**WELWYN HATFIELD BOROUGH COUNCIL
EXECUTIVE DIRECTOR - PLANNING, PUBLIC PROTECTION AND GOVERNANCE**

Application No: 6/2018/2102/FULL
Location: Oak Cottage Residential Home 4 Wilkins Green Lane Hatfield AL10 9RT
Proposal: Retention of two storey rear extension
Officer: Ms Lucy Hale

Recommendation: Granted

TITLE  
**PROPOSED  
 ROOF PLAN & ELEVS**  
 ADDRESS  
**OAK COTTAGE CARE HOME,  
 4 WILKINS GREEN LANE,  
 HATFIELD, AL10 9RT.**  
 SCALE  
**1 : 100 @A2**  
 DATE  
**JUL 2019**  
 DRAWING NO.  
**OCCH 102-2**  
 REV.  
**B**

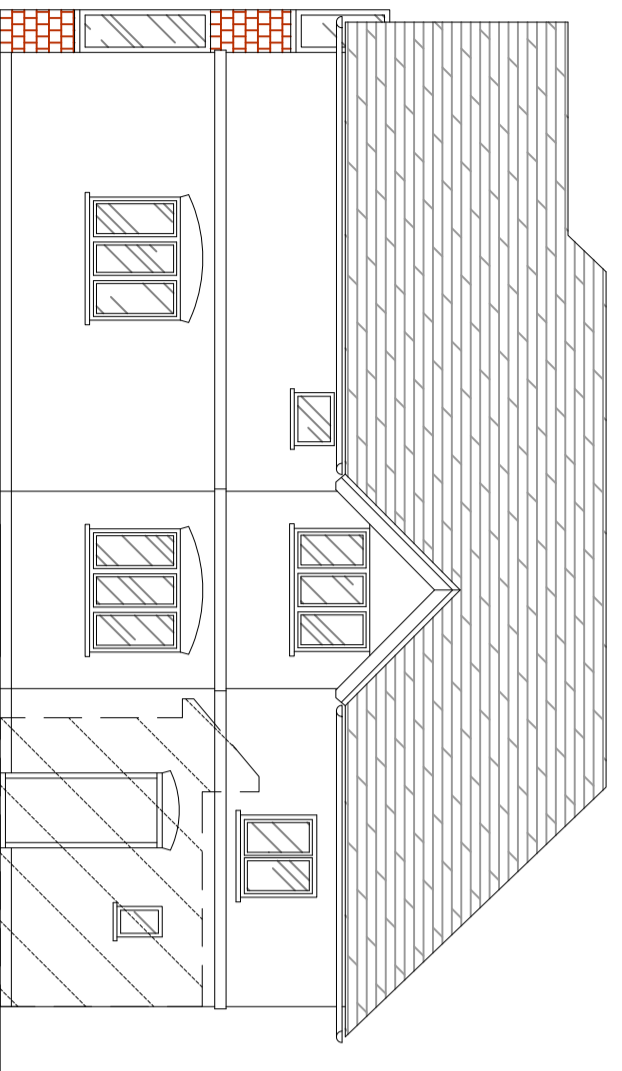
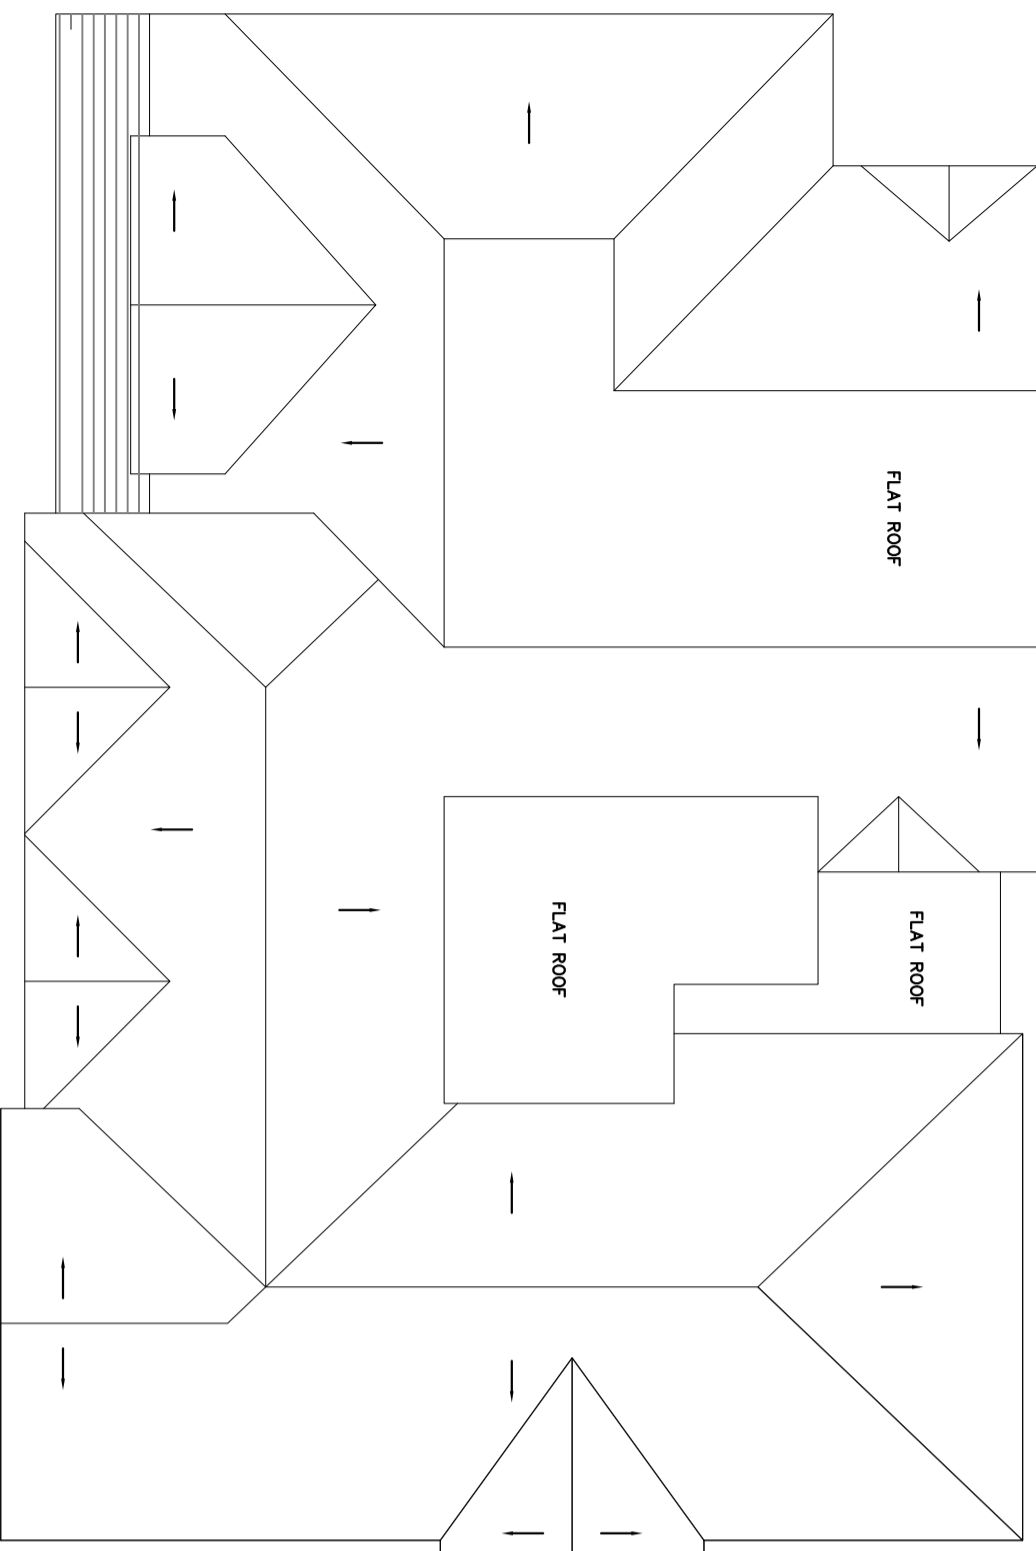
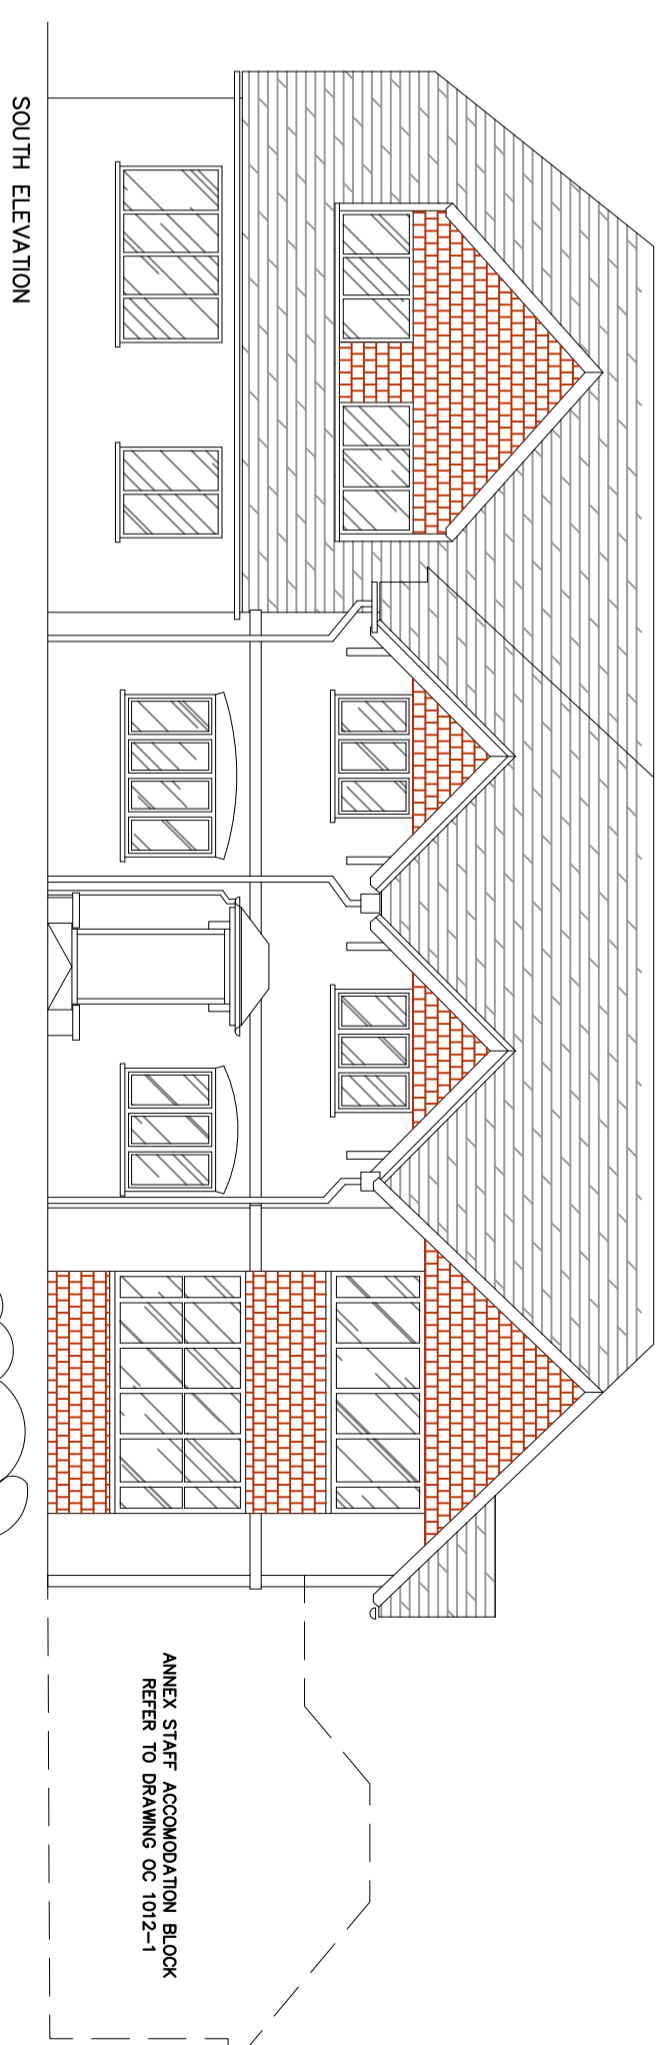
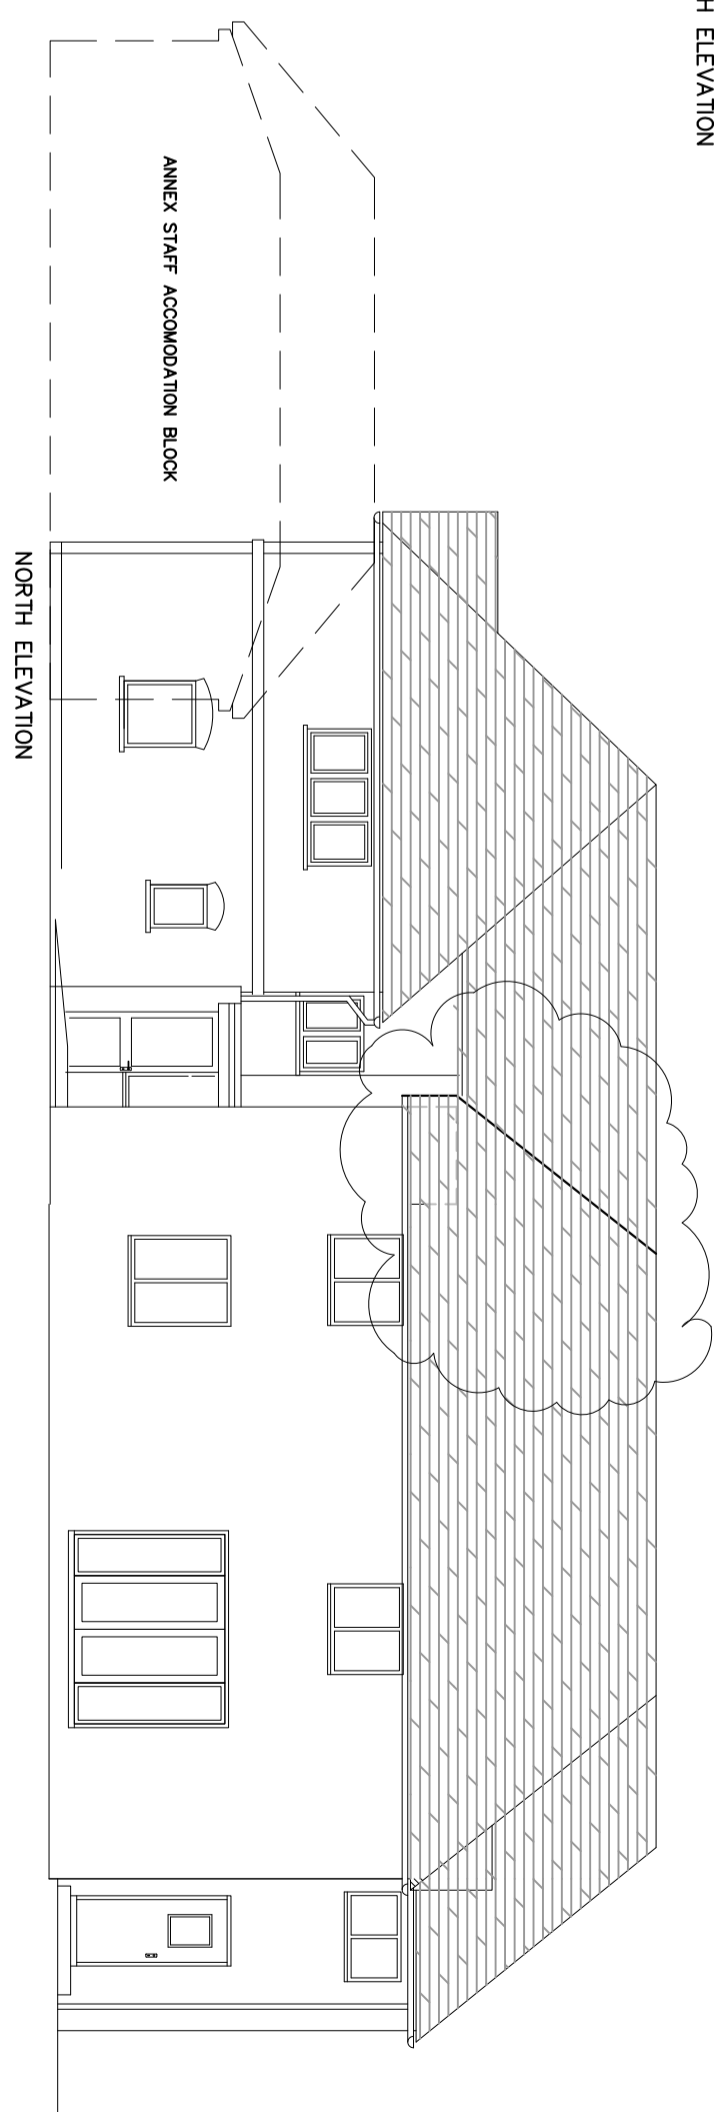
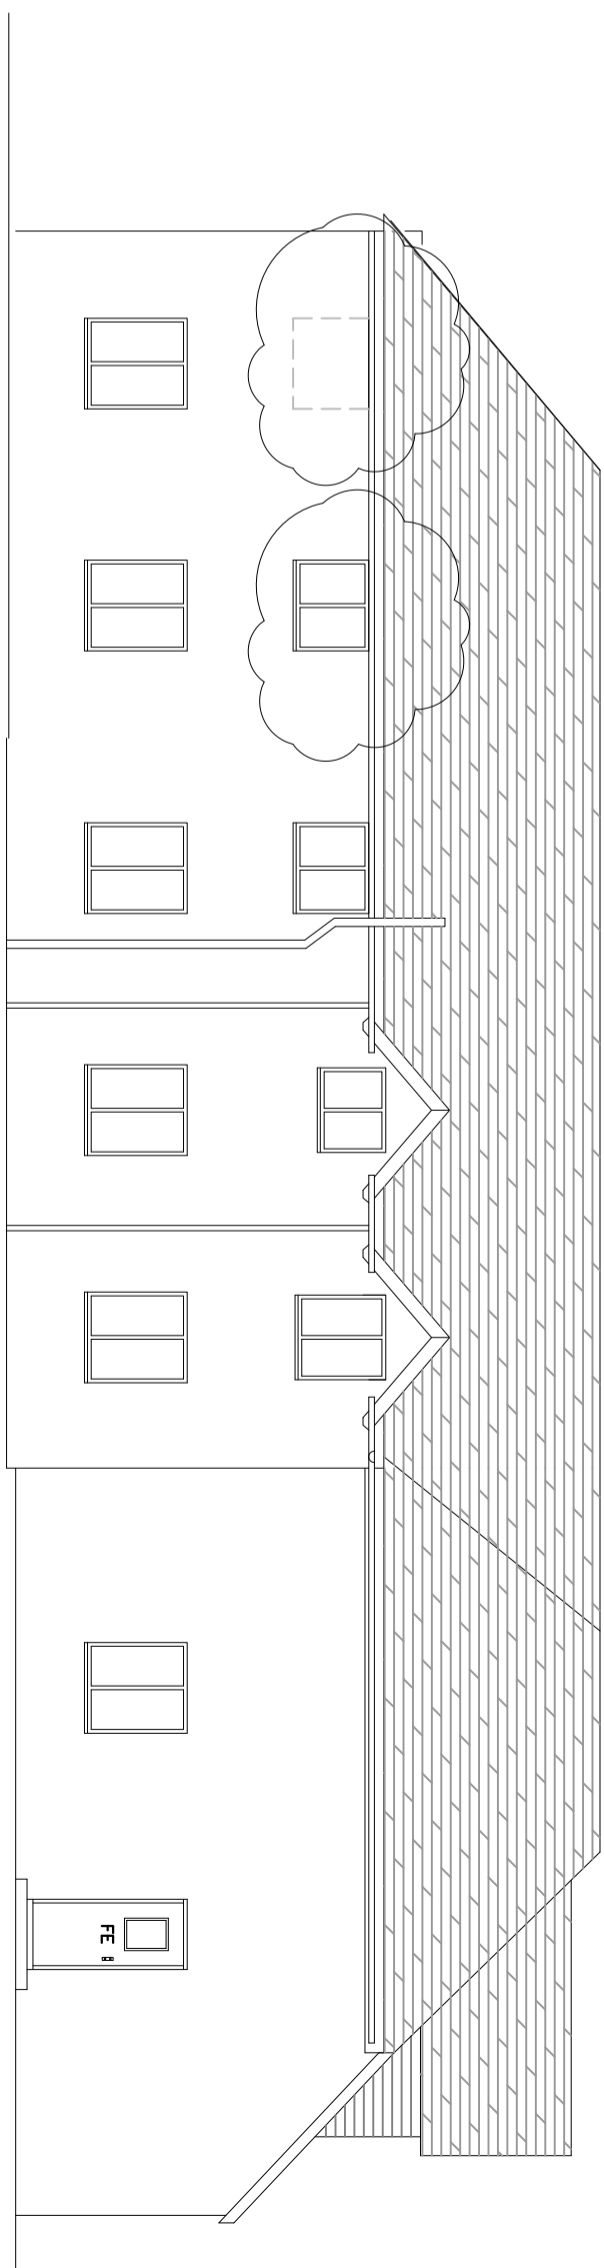
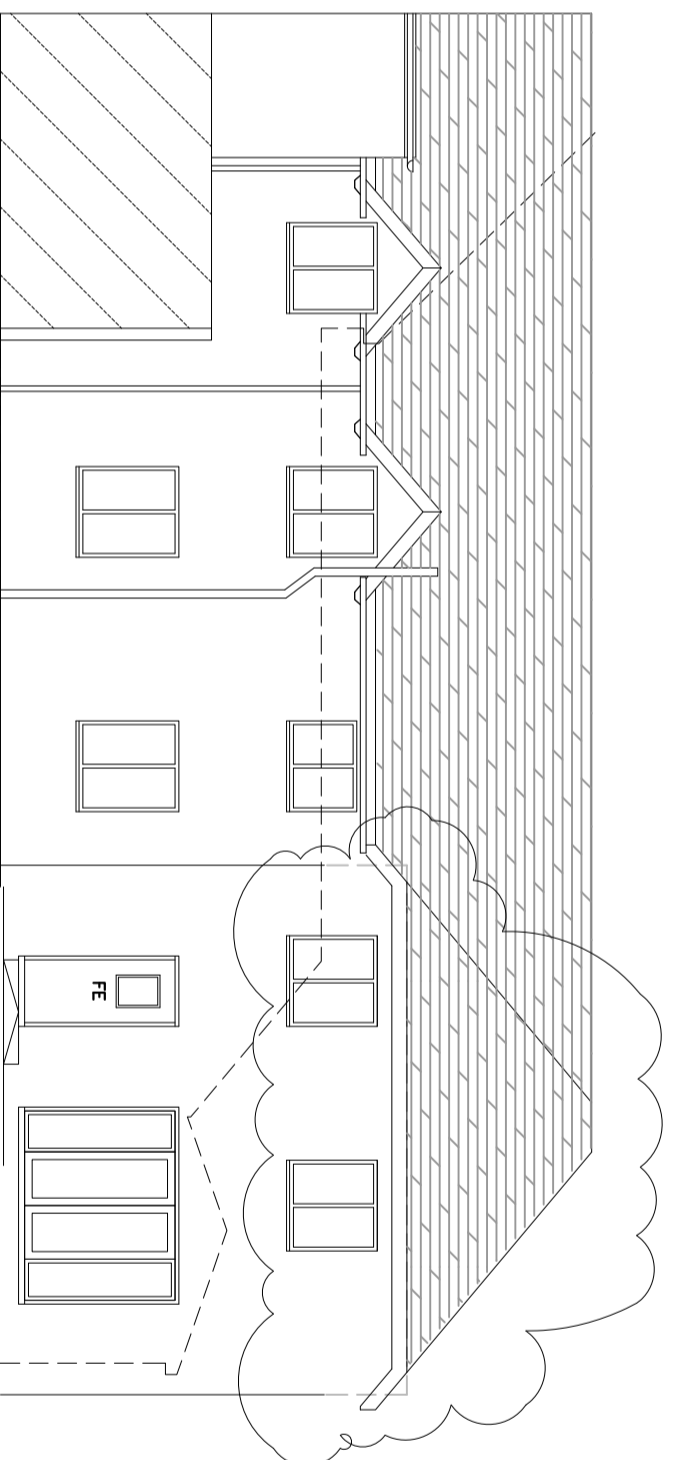
Following a site visit it is noted that the development has not been built in accordance with the plans. The crown roof has been extended in line with the footprint allowed at appeal with a two storey flat roof element to the side. Following discussions with the applicant, the drawings have been amended to a pitched roof over the existing flat roof.

The bulk and massing of the roof would be increased compared to that allowed at appeal, however the footprint would remain and part of the flat roof extension has not been implemented. In addition, the continued crown roof and hipped element are considered to respect and relate to the design and appearance of the building. Furthermore, the development is located to the rear of the site and therefore would not be unduly visible from public vantage points. It is considered that the proposed extension would not have an adverse effect on the character of the area.

In the case of No. 3, the Inspector concluded that there would be a distance of over 30 metres between the main part of the extension and the flank wall of that property and also screening as a result of the staff annex building and the boundary fence. An additional window has been proposed on the east side elevation of the building to serve a secondary bedroom window. It would be reasonable to condition this window as obscure glazed and non-opening below 1.7 metres to maintain an acceptable relationship with the neighbouring occupiers in regard to privacy.

1. The alterations to the building hereby approved and as shown on drawing numbers OCCH 102-1 Rev A and OCCH 102-2 Rev B dated July 2019 shall be commenced within 3 months of the date of this decision and be fully completed within 6 months of the date of this decision.

3. The window located in the wall forming the west side elevation of the building serving an office and the window on the east side elevation of the building serving a secondary bedroom window hereby approved must be obscure-glazed and non-opening unless the parts of the window which can be opened are more than 1.7 metres above the floor of the room in which the window is installed, and shall be retained in that form thereafter.
